**SUBMISSION TO THE DEPARTMENT OF PLANNING AND INFRASTRUCTURE ON THE PROPOSED
NORTH WEST RAIL LINK (NWRL)**

Name: CONNOR PLUMES

Application Number: SSI-5100

Figure 6.11 Cheltenham Services Facility light vehicle access and egress

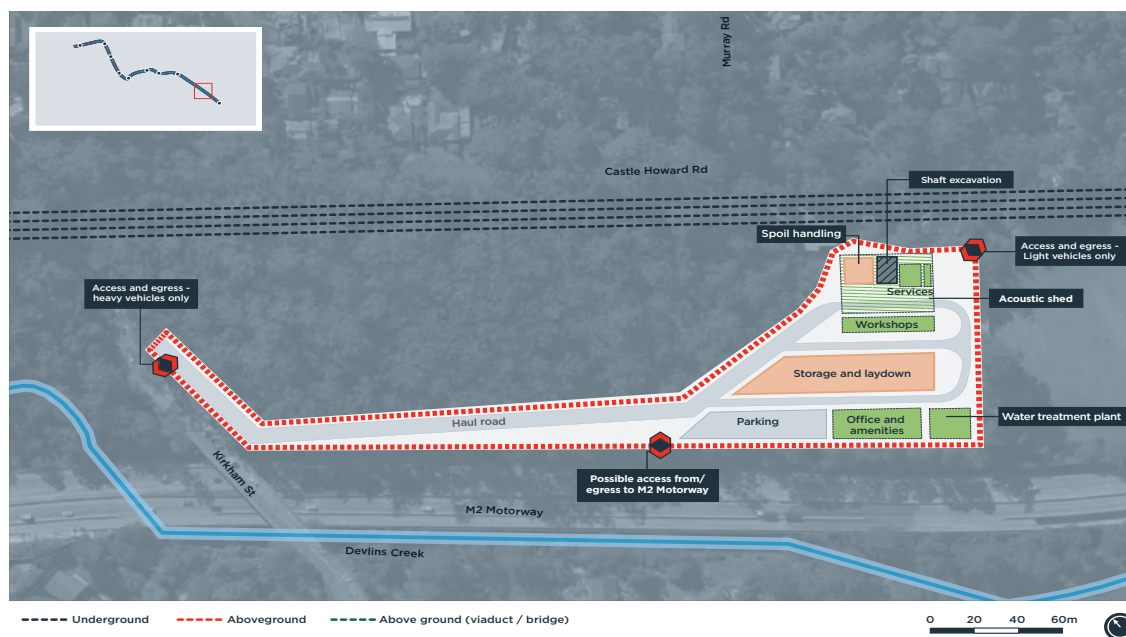
1. The option to construct a new two lane paved road through the Castle Howard Conservation Reserve to Kirkham Street (or Castle Howard Road) near the bridge over the M2 to allow trucks to remove spoil during construction and light vehicle access during operation of the facility will permanently destroy valuable Blackbutt Gully forest.

5. Should the roadway be built, the local streets (Kirkham Street, Castle Howard Road, Murray Farm Road and the bridge over the M2) are narrow, winding and congested and would not be suitable for trucks and, in the event of an emergency, large numbers of emergency vehicles.

I therefore ask that you adopt the alternative option of access to the site for construction and emergency vehicles be via new on and off ramps from the M2 motorway. The current widening and reinstatement of the breakdown lane should allow this access. It is the only practical way to move trucks in and out of the site. In the event of an emergency, many emergency vehicles would need quick access to the site from areas outside Beecroft and Cheltenham as it only has one fire engine.
